## **Additional representation in respect of the Bramford to Twinstead project submitted by Belinda Nott**

I write as the daughter of an affected landowner and as a resident of Pebmarsh.

HAUL ROAD - V 5

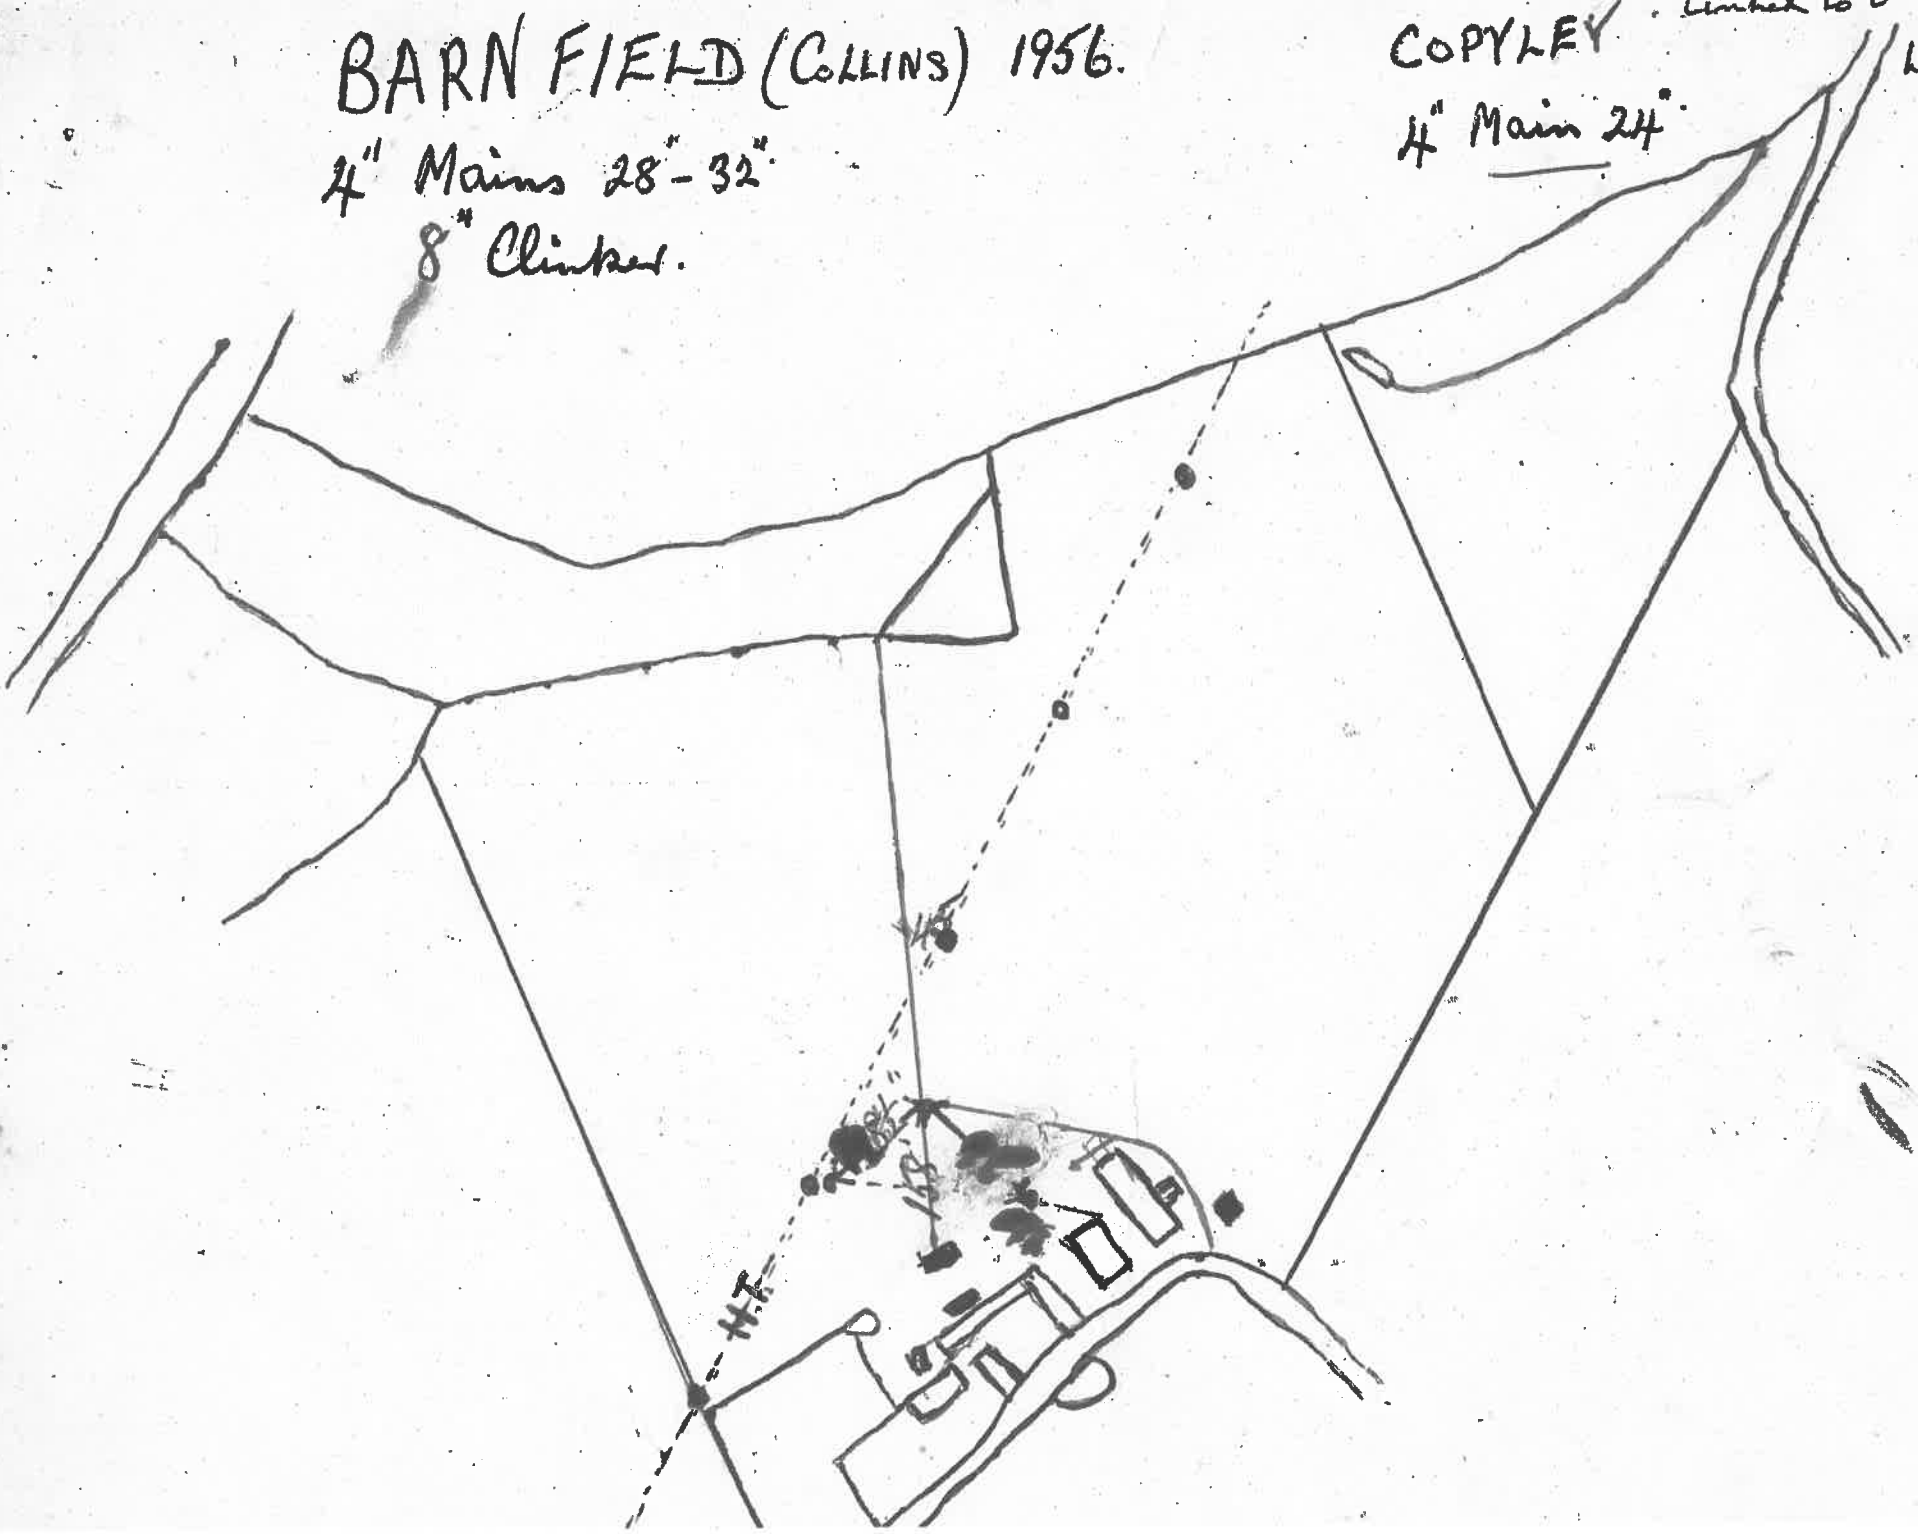
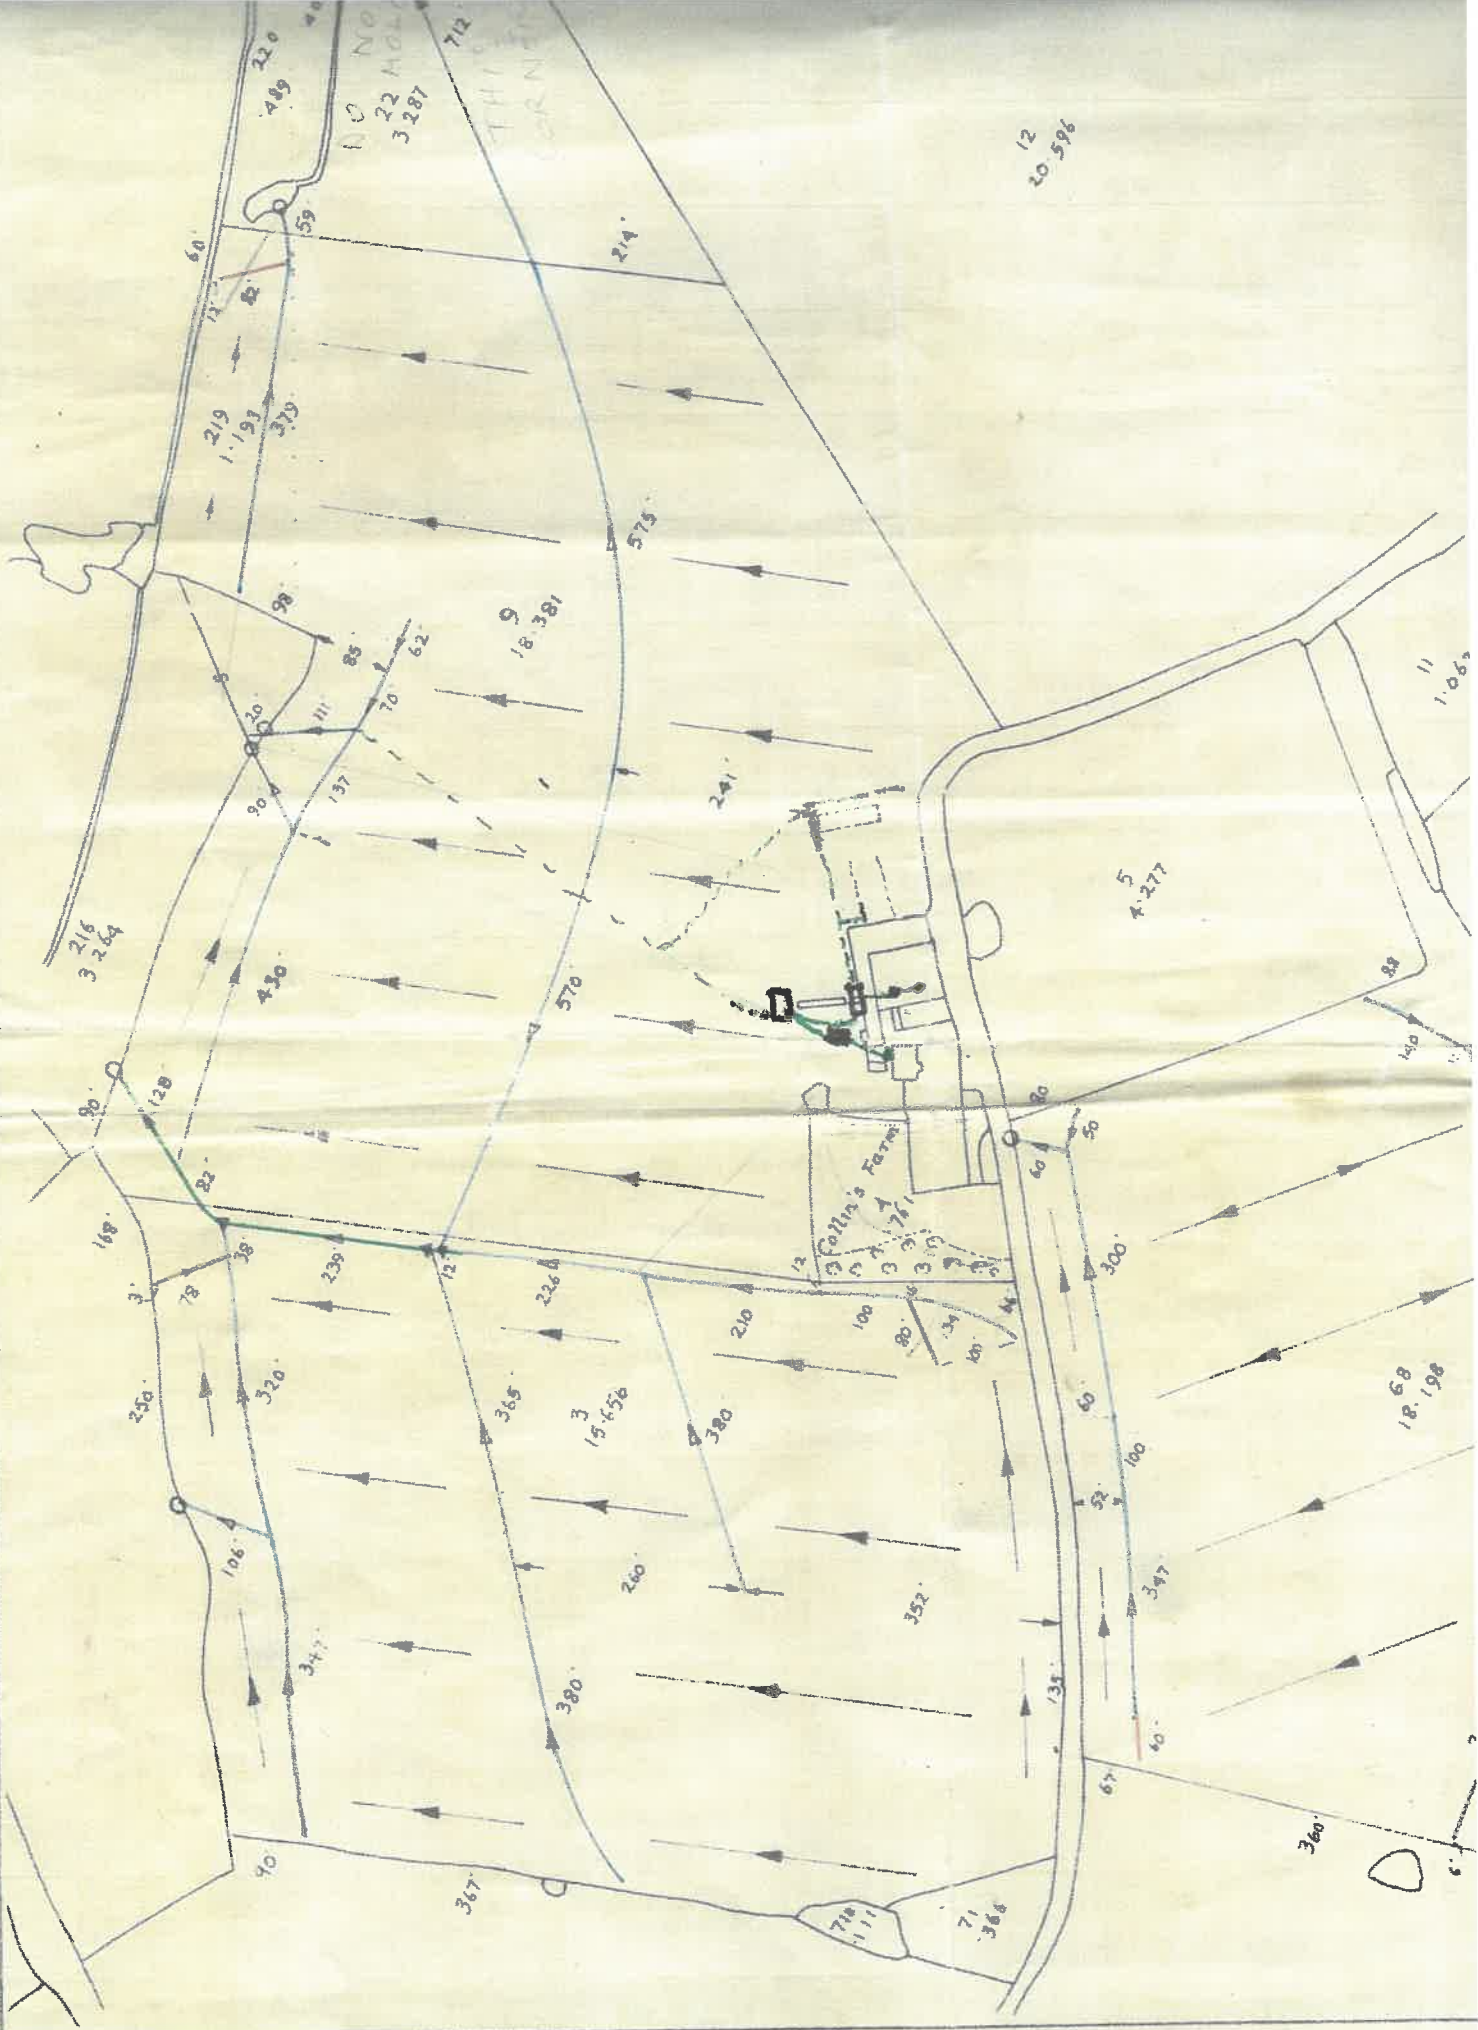
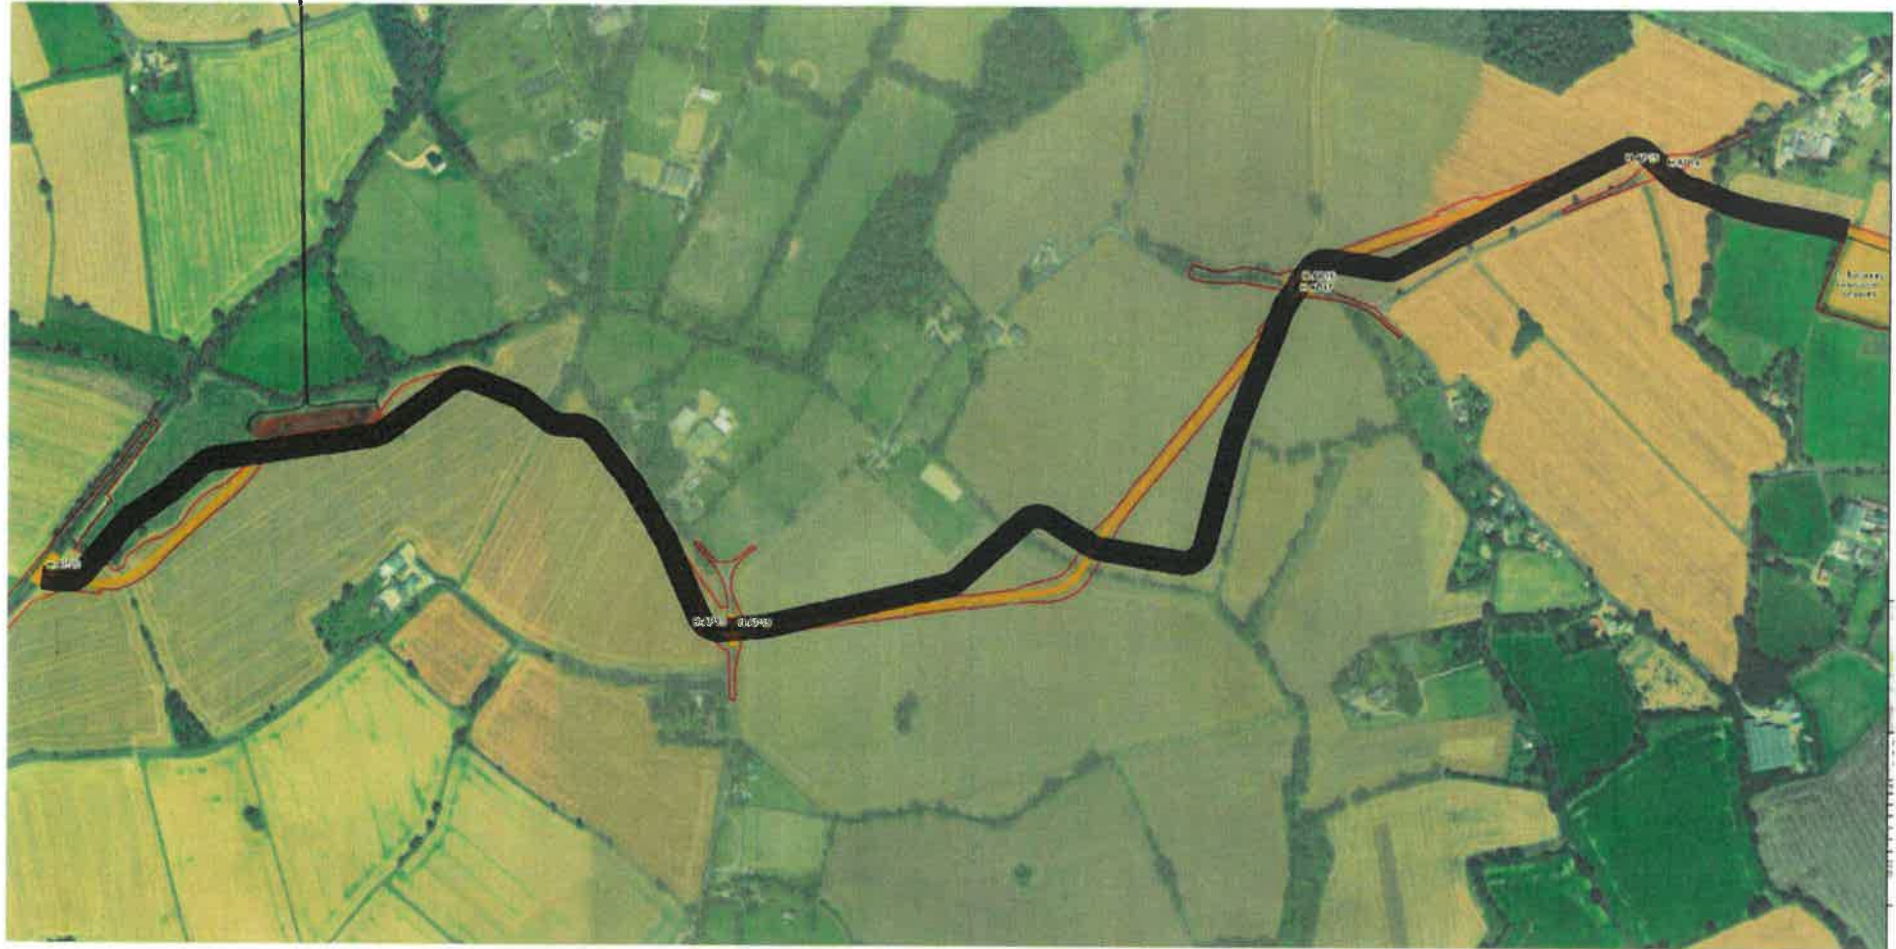
If the roads are proven to not be suitable, I ask you to please consider making NG use an alternative route around the boundary of my father's two largest fields which would less affect farming operations and field drainage. If detailed terms could be agreed, this could be left in situ and landscaped with less disruption if needed again in the future.
